Final Report - Corrections Required
Application No. ANEX-23-0014

Description : A request by Norris Ranch Joint Venture, LLC, for annexation of 19.605 acres into the City of Colorado Springs. The annexation is a part of the overall Karman Line Land Use Plan, which is being submitted concurrently. The Land Use Plan proposes a maximum of 6,500 dwelling units, approximately 45 acres of light industrial, 105 acres of commercial/retail, 100 acres of mixed-use development, and 570 acres of park/open space.

Document Filename : KARMAN VICINITY MAPS 2023-03-27.pdf

EXHIBIT A  
KARMAN LINE NO. 1

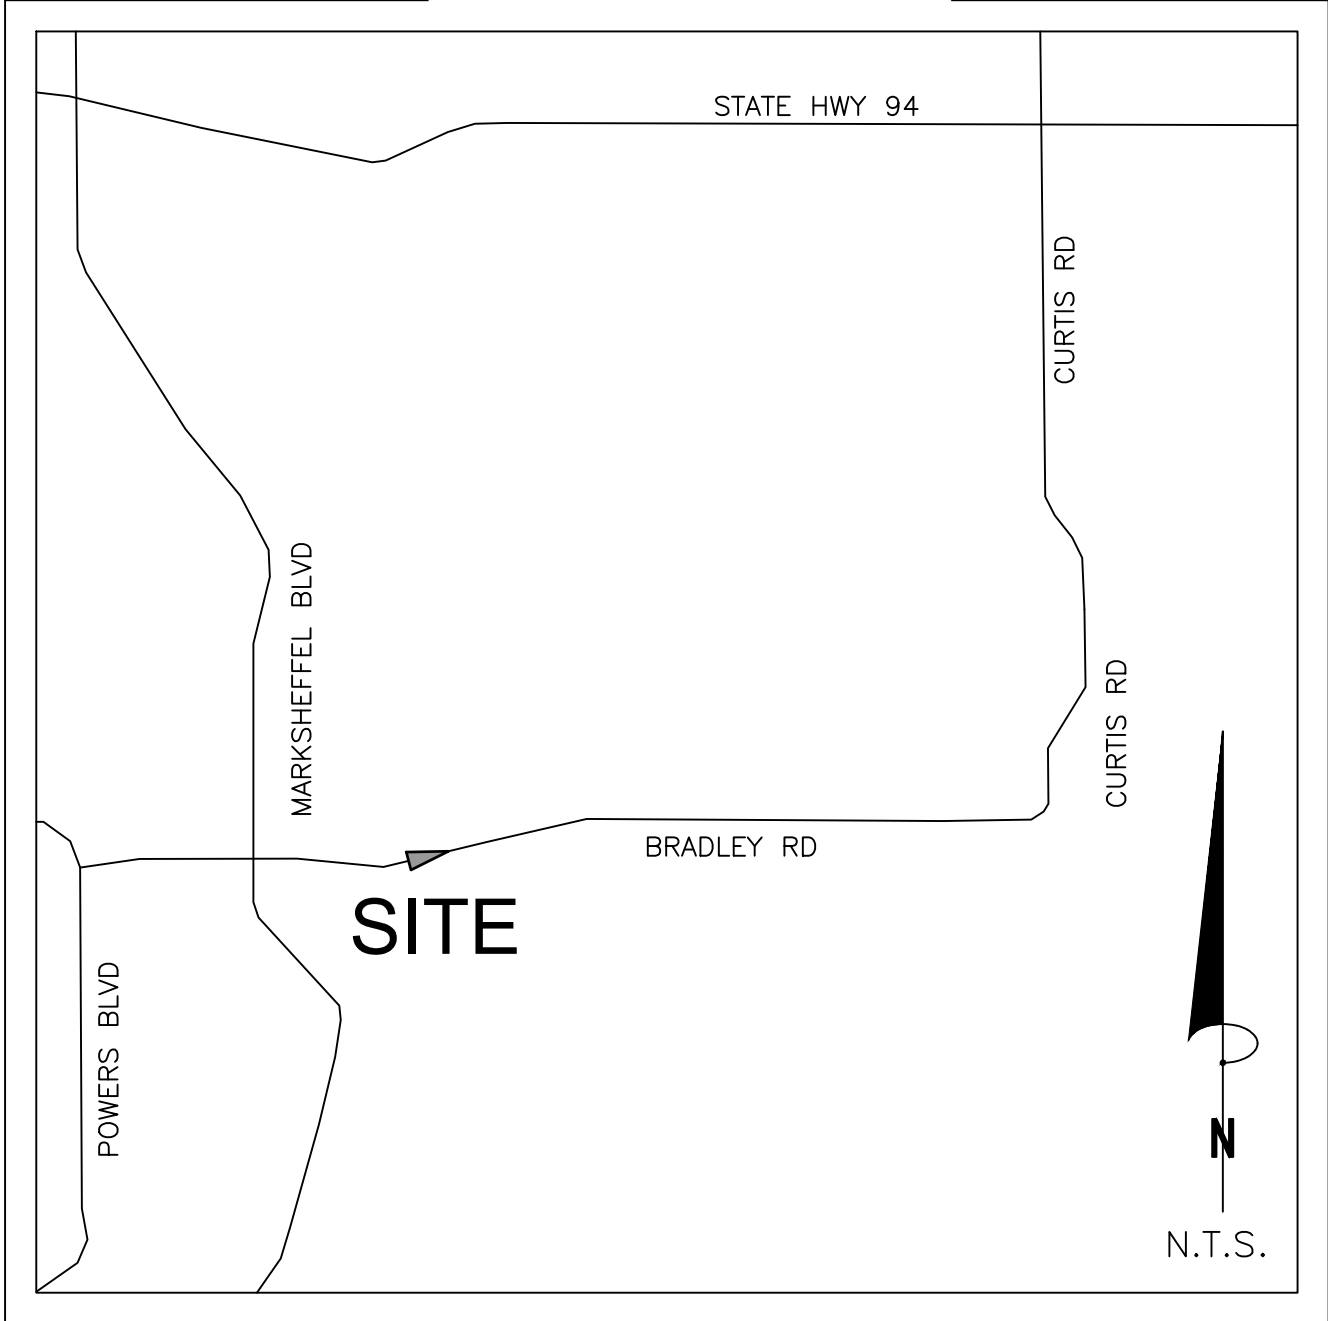
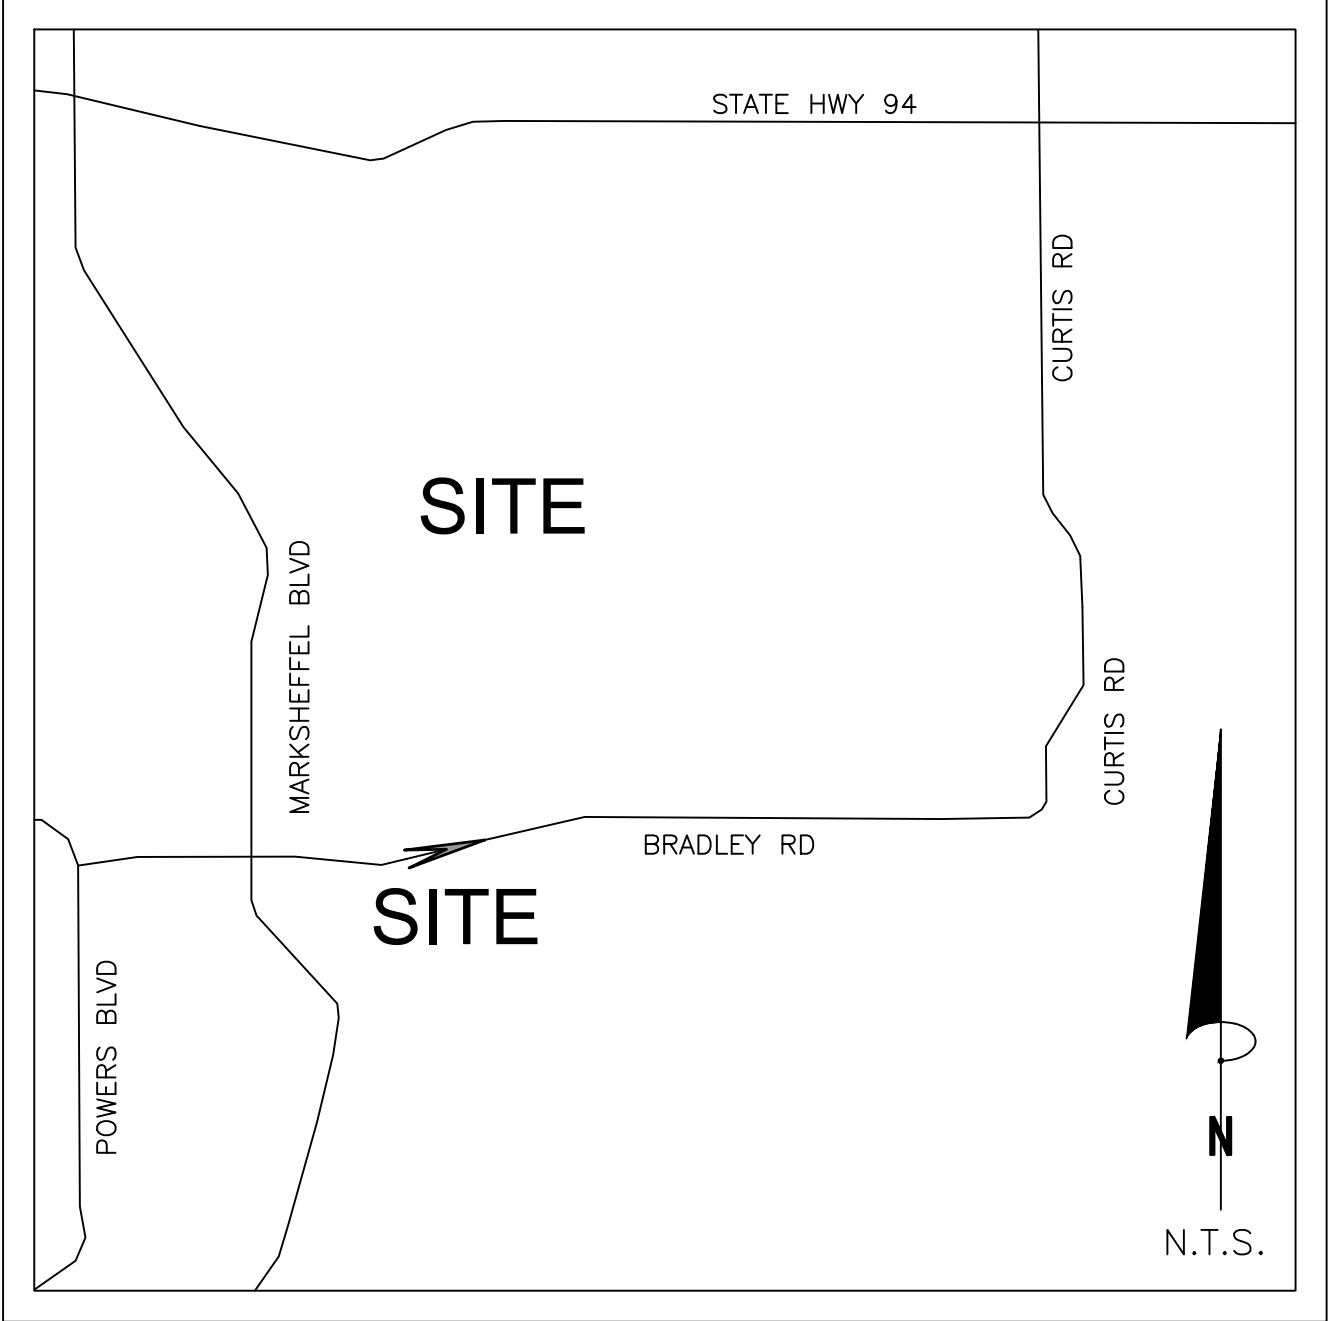
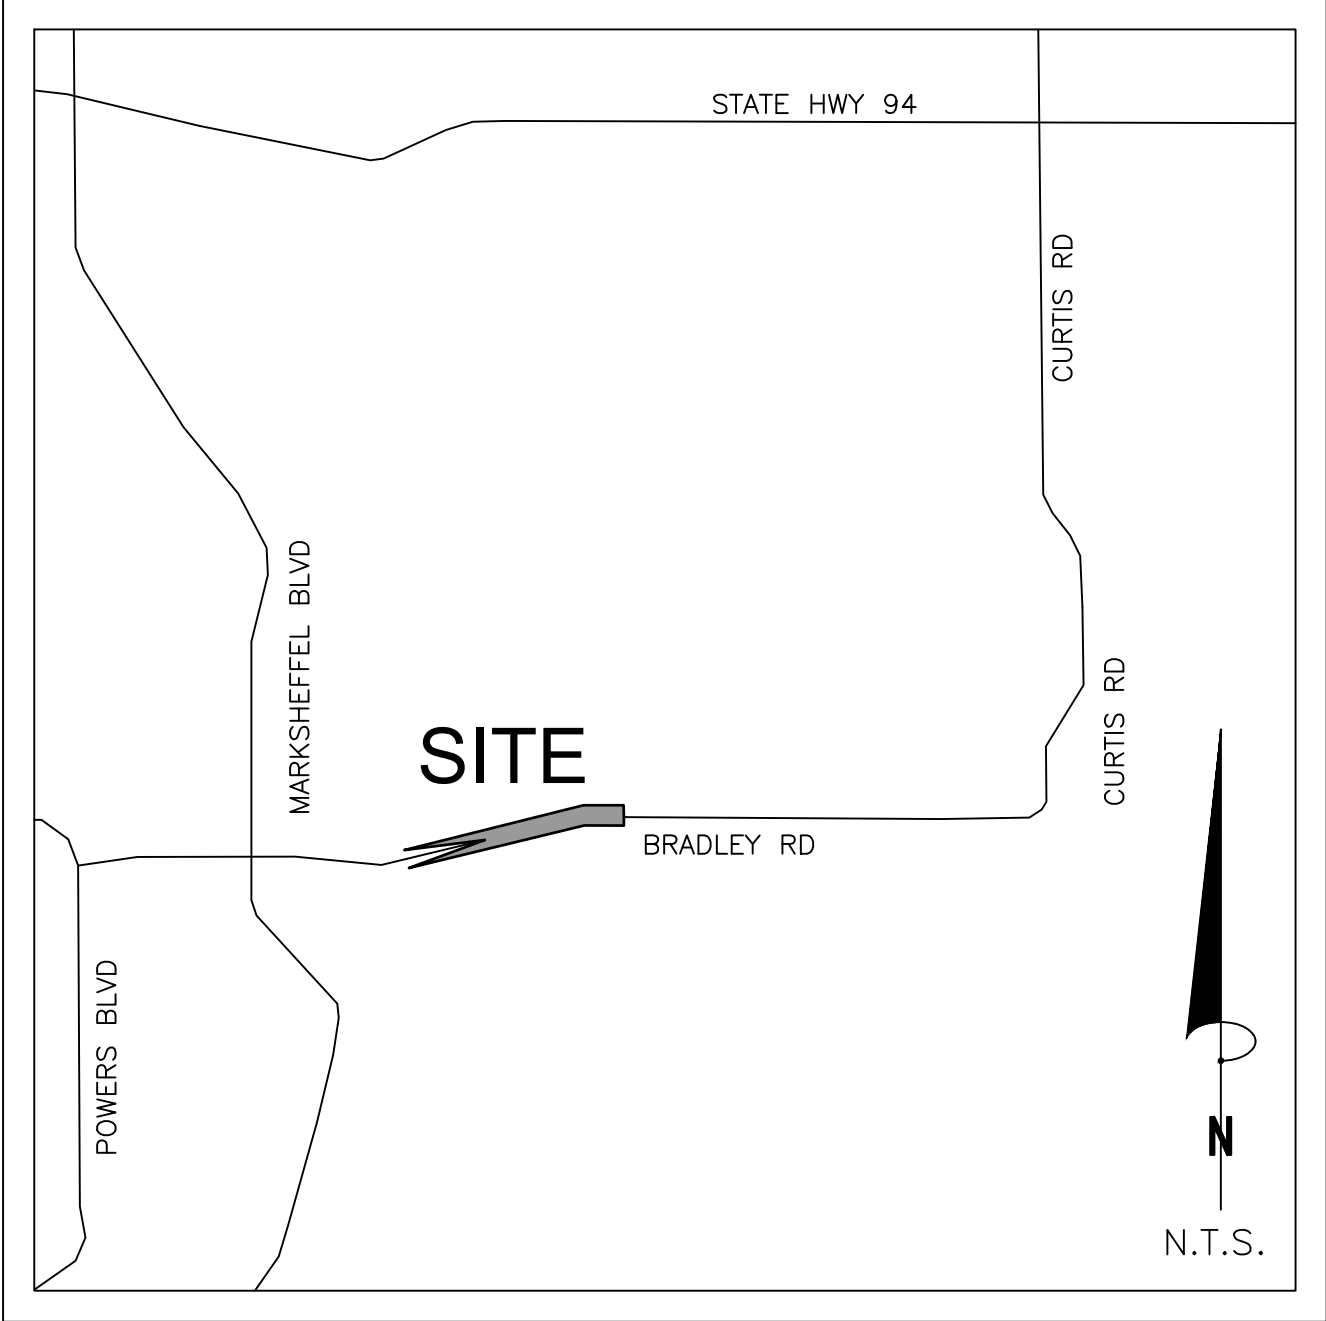
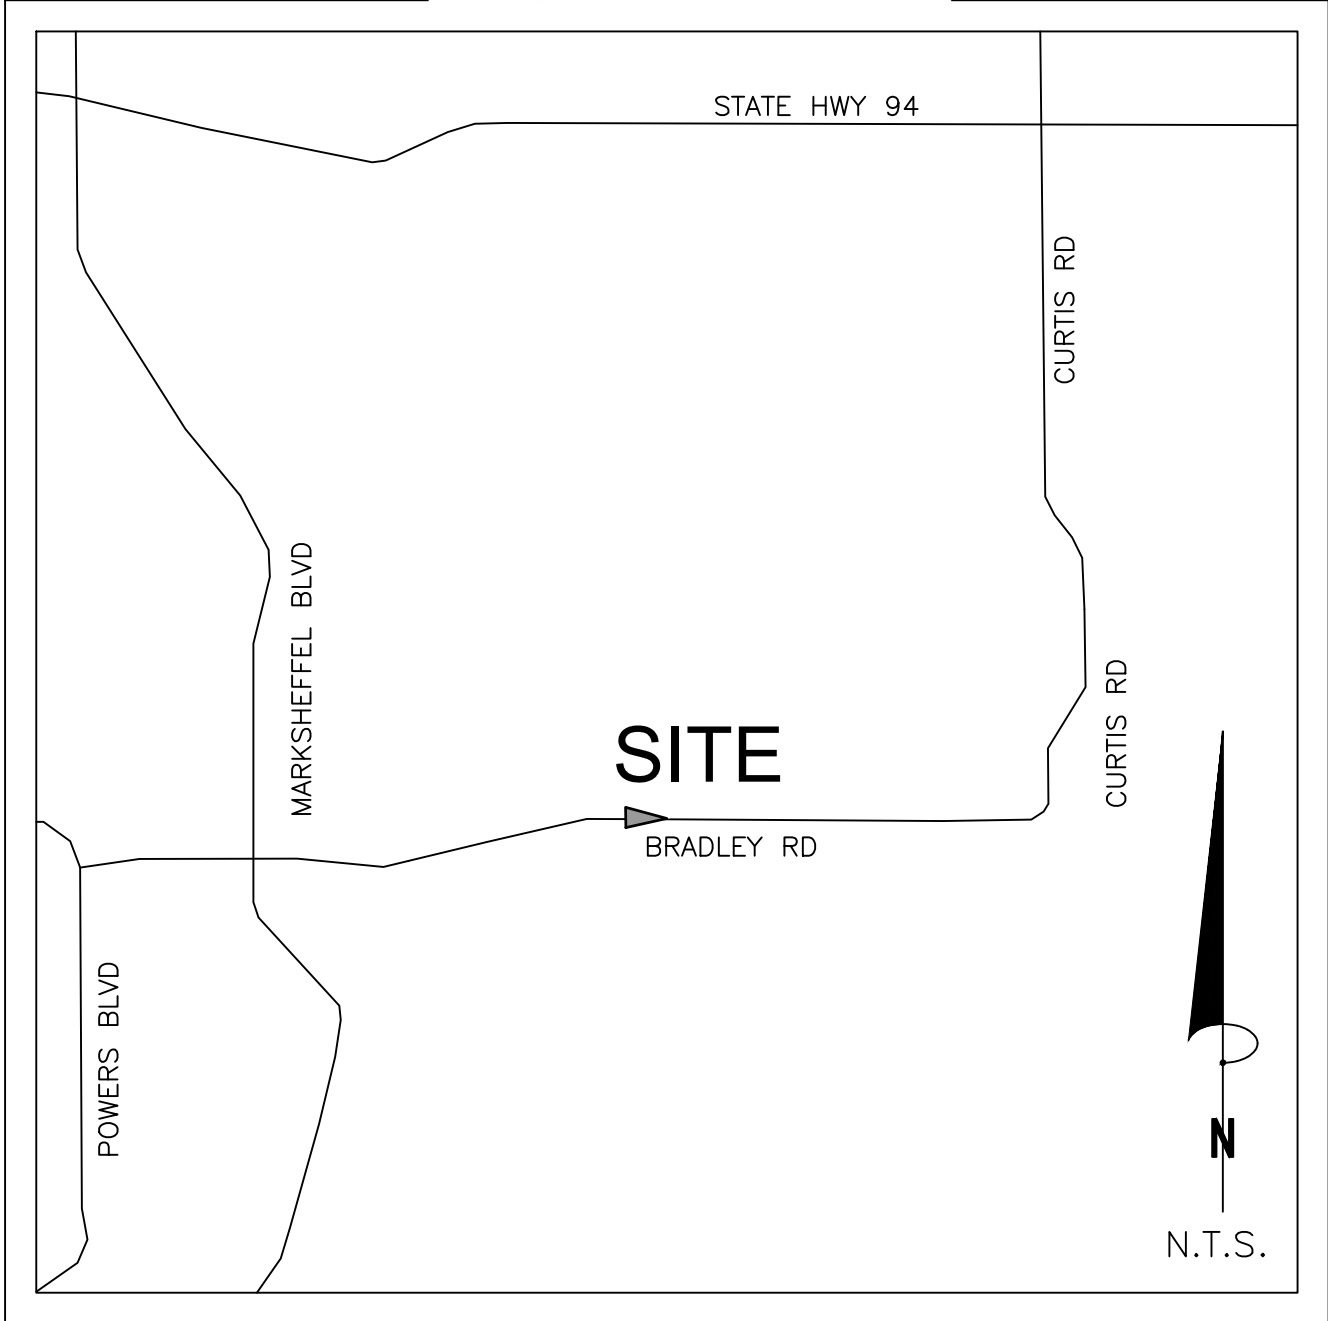
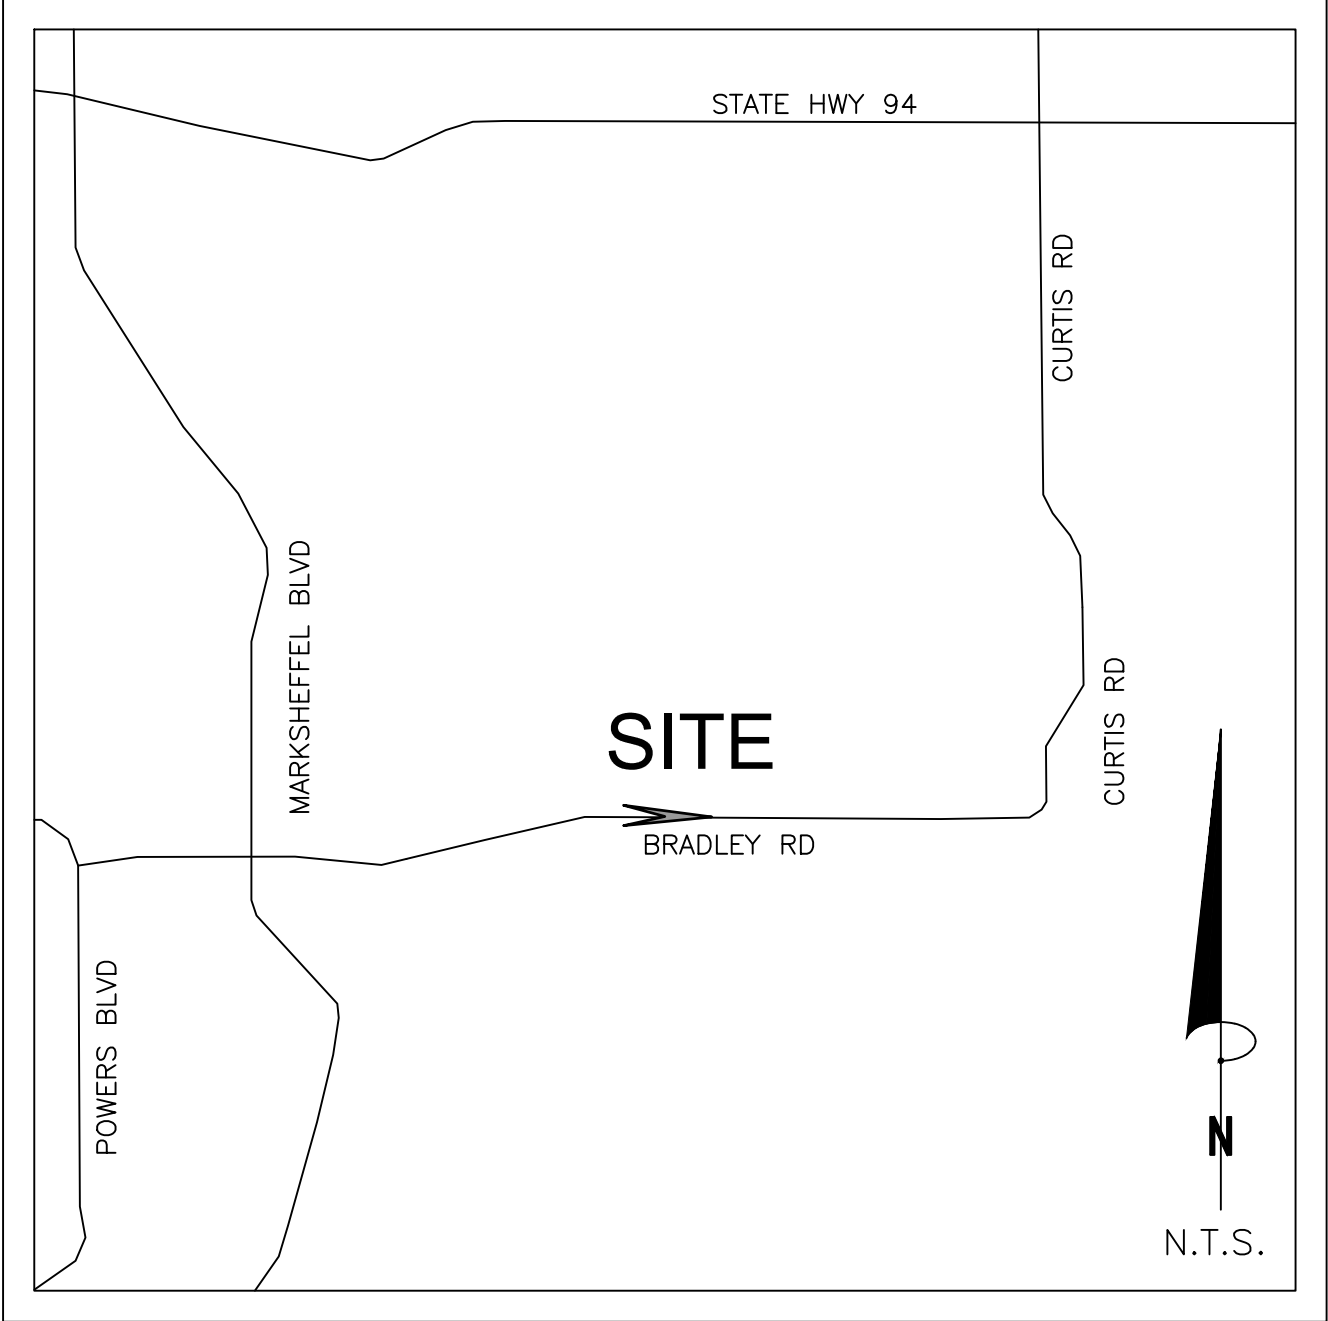
Comment ID	Page Reference	Author : Department	Review Comments
29	6	Dan Sexton : Planning	In addition to the already provided vicinity maps for each annexation plan that is part of the serial annexation request, please provide an overall vicinity map that depicts all of the area to be annexed.
